ENG-PUDSP21006-R3-GEC.pdf Markup Summary

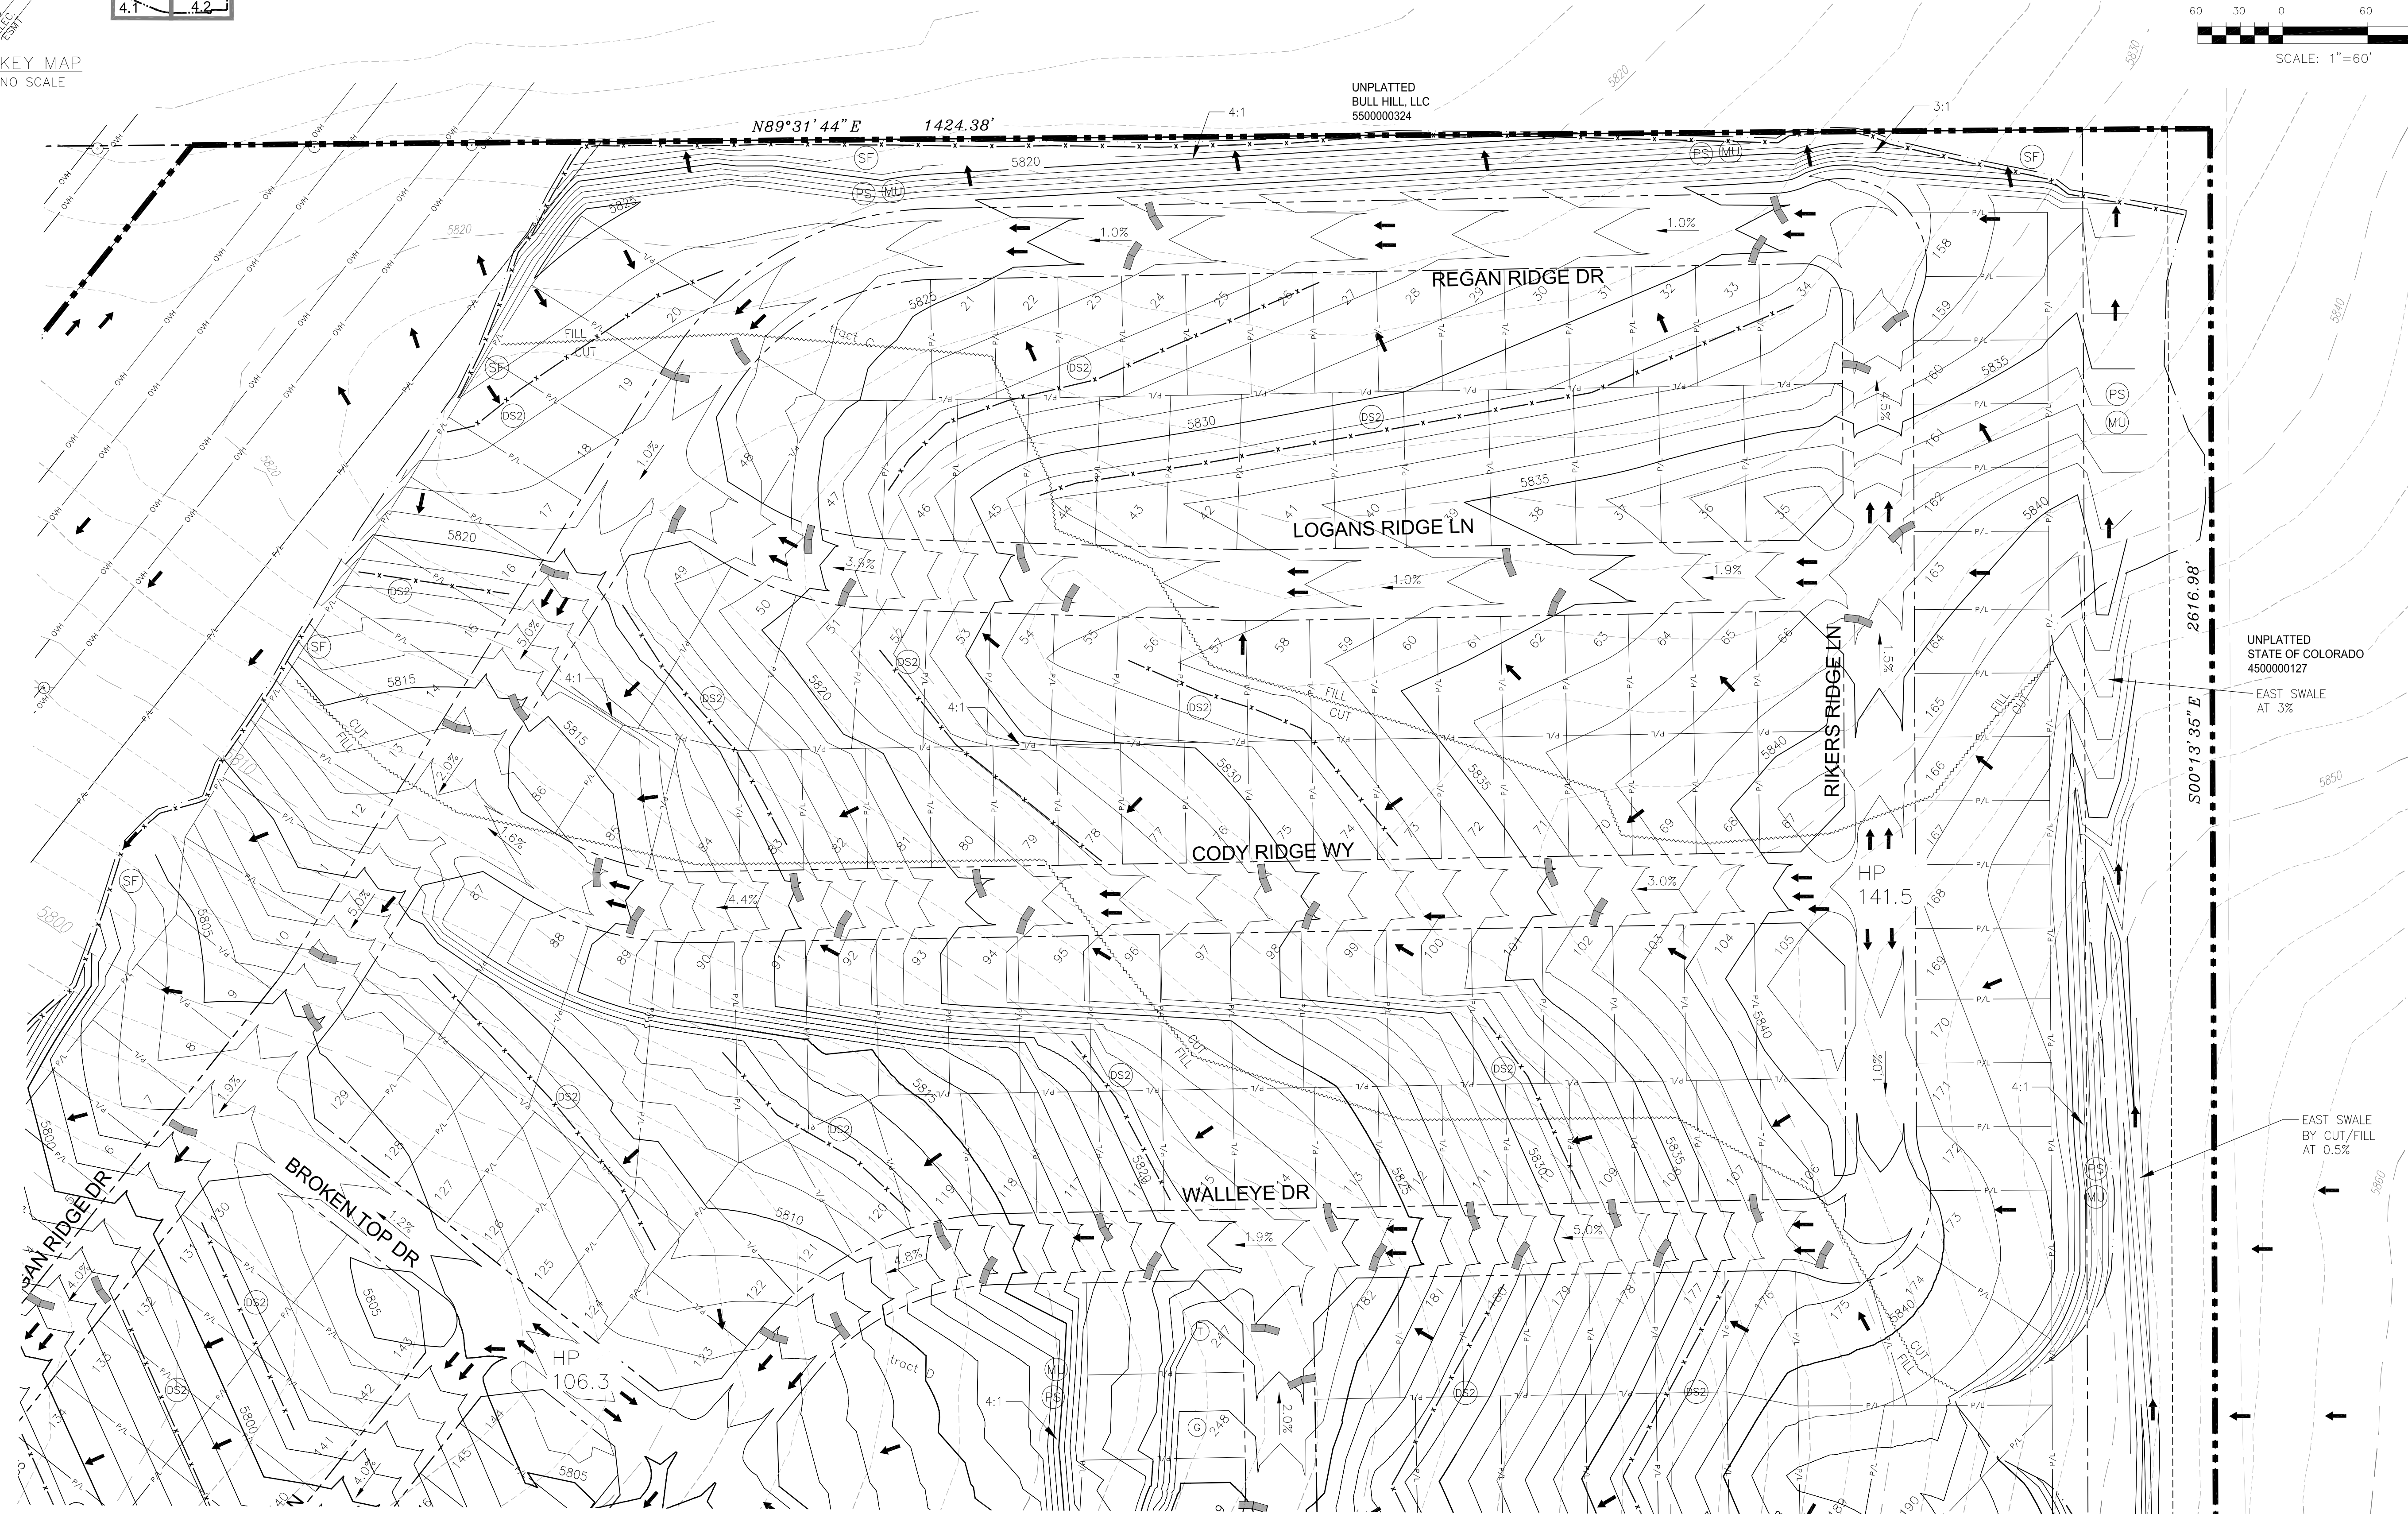
Provide downstream easement and conveyance of spreader system

High velocity needs protection

POND C2.1  
EMERGENCY OVERFLOW  
AND CONCRETE CUTOFF WALL  
PROFILE  
SCALE: NTS

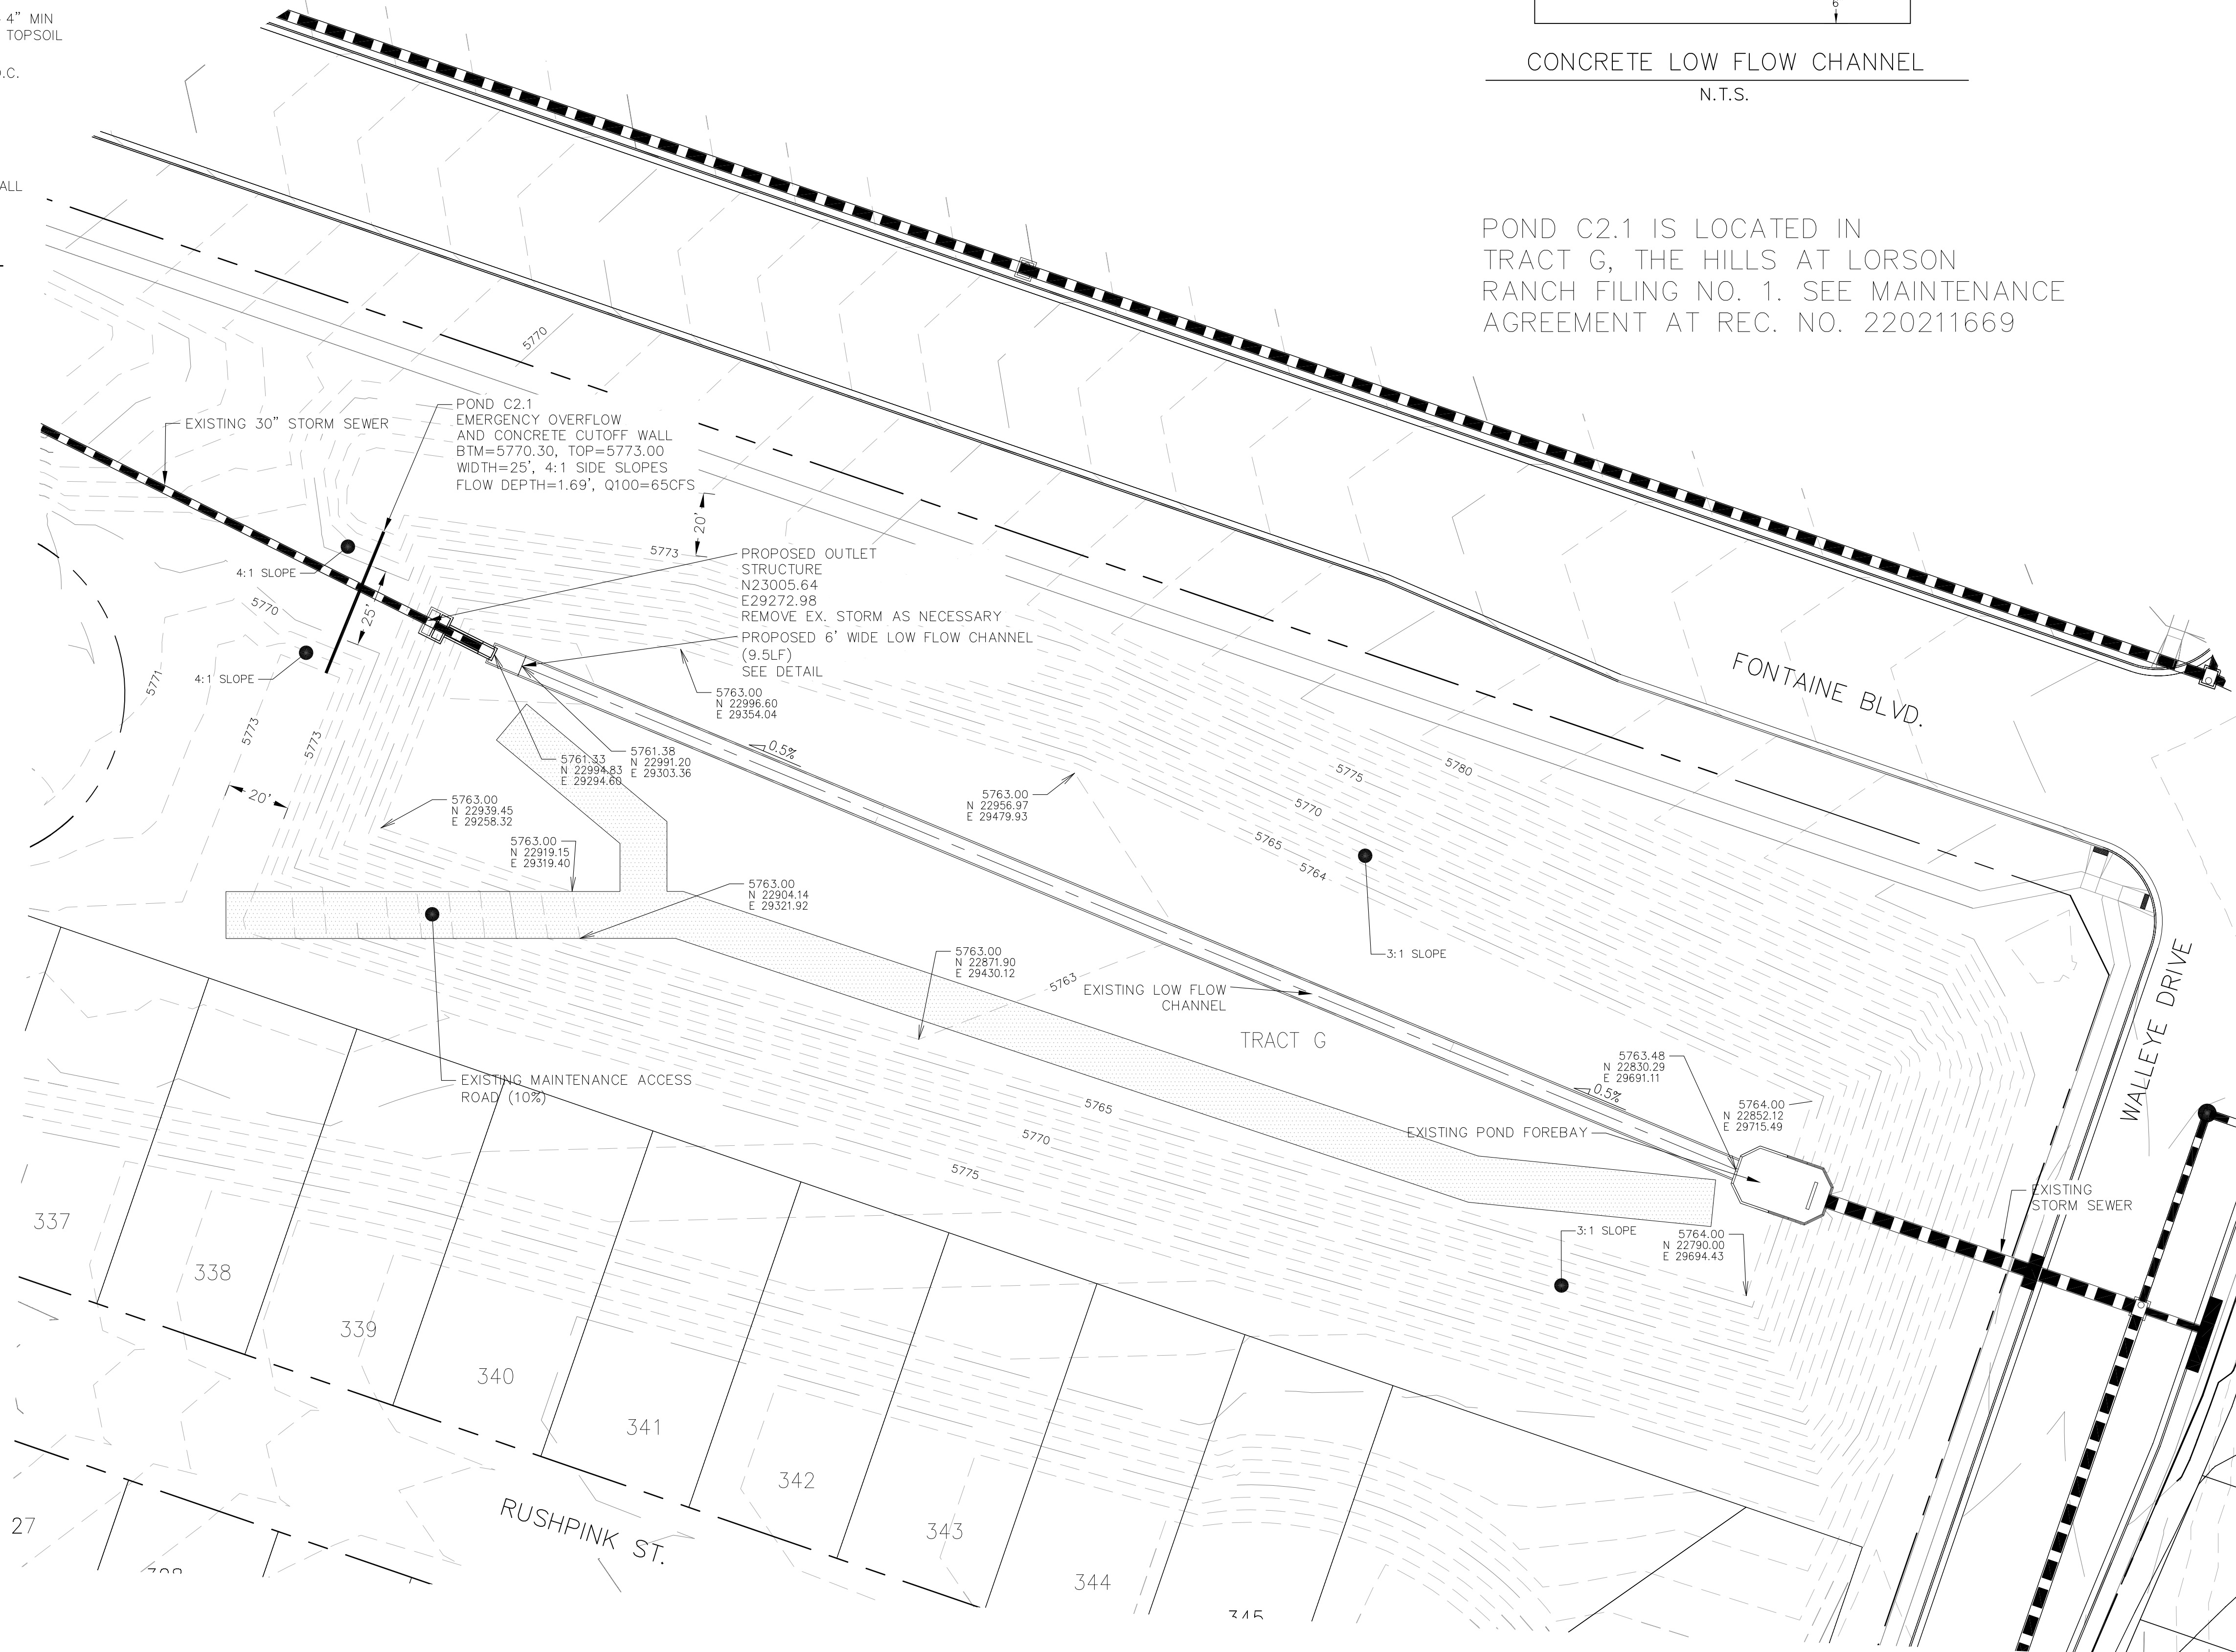
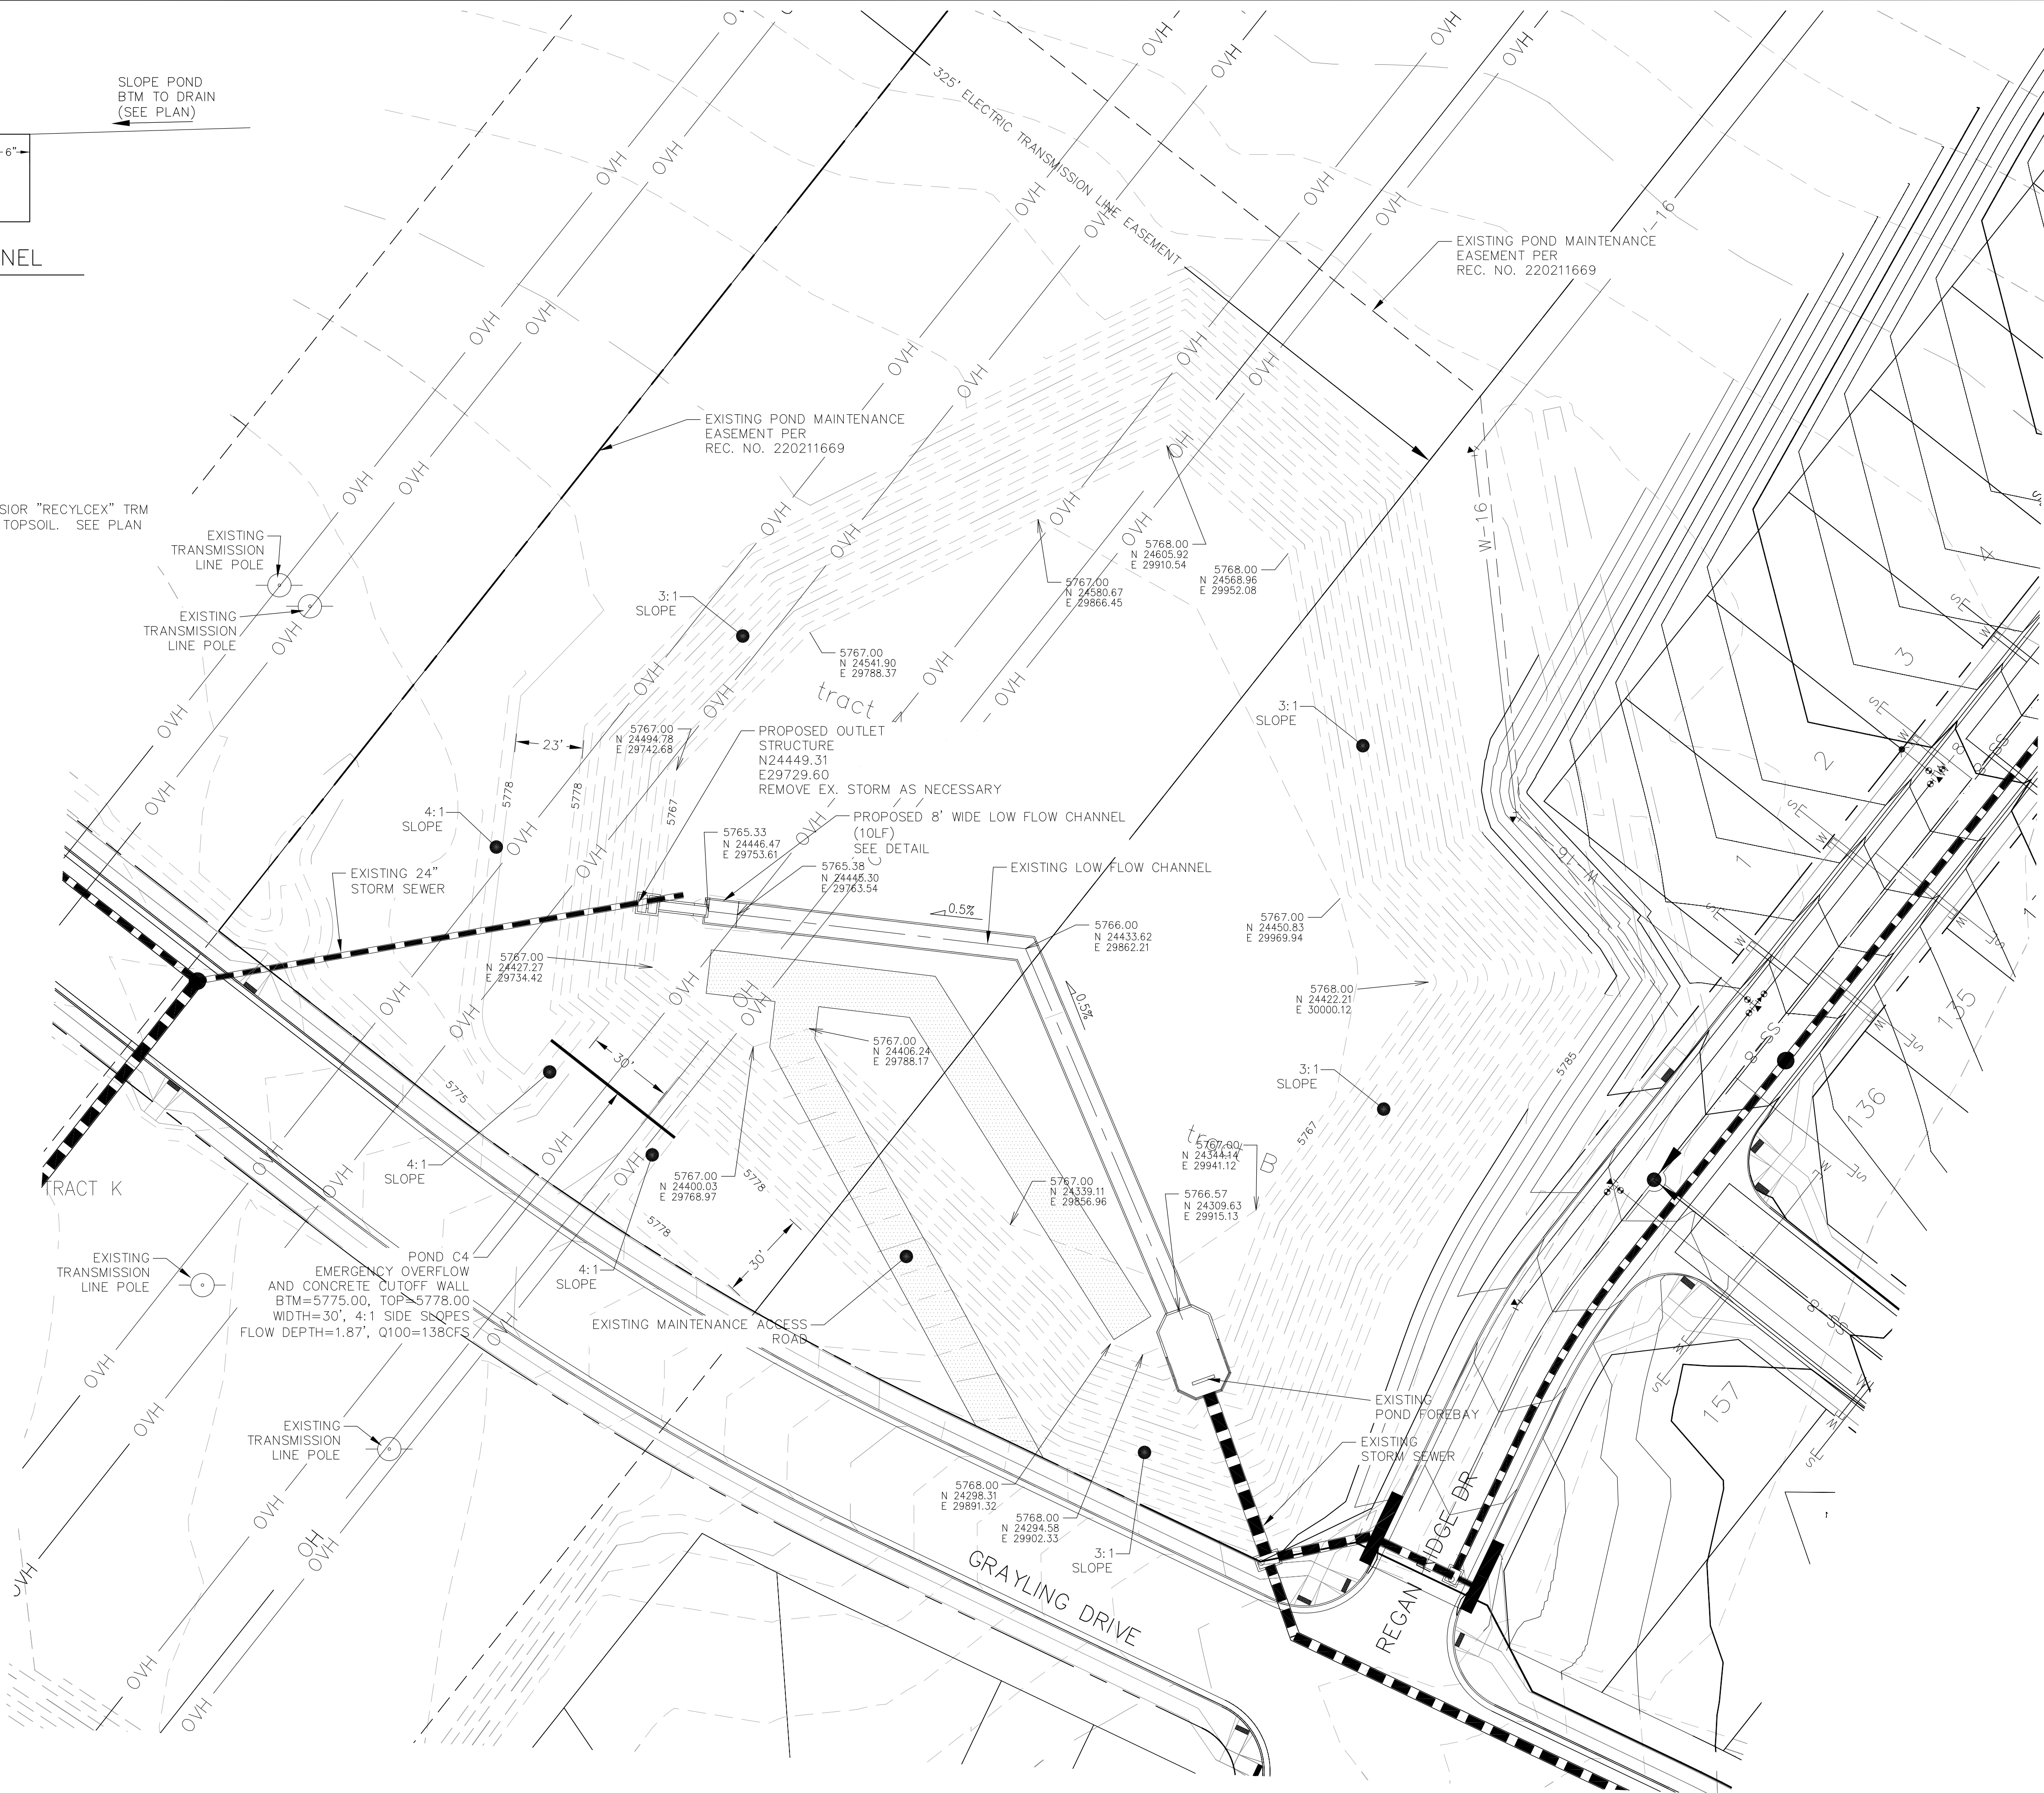
A cutoff wall is recommended to prevent spillway failure.

Consider using soil riprap for the overflow per detail in Chapter 12 of MHFD USDCMv2, pg 12-33 as well as placing ECB.
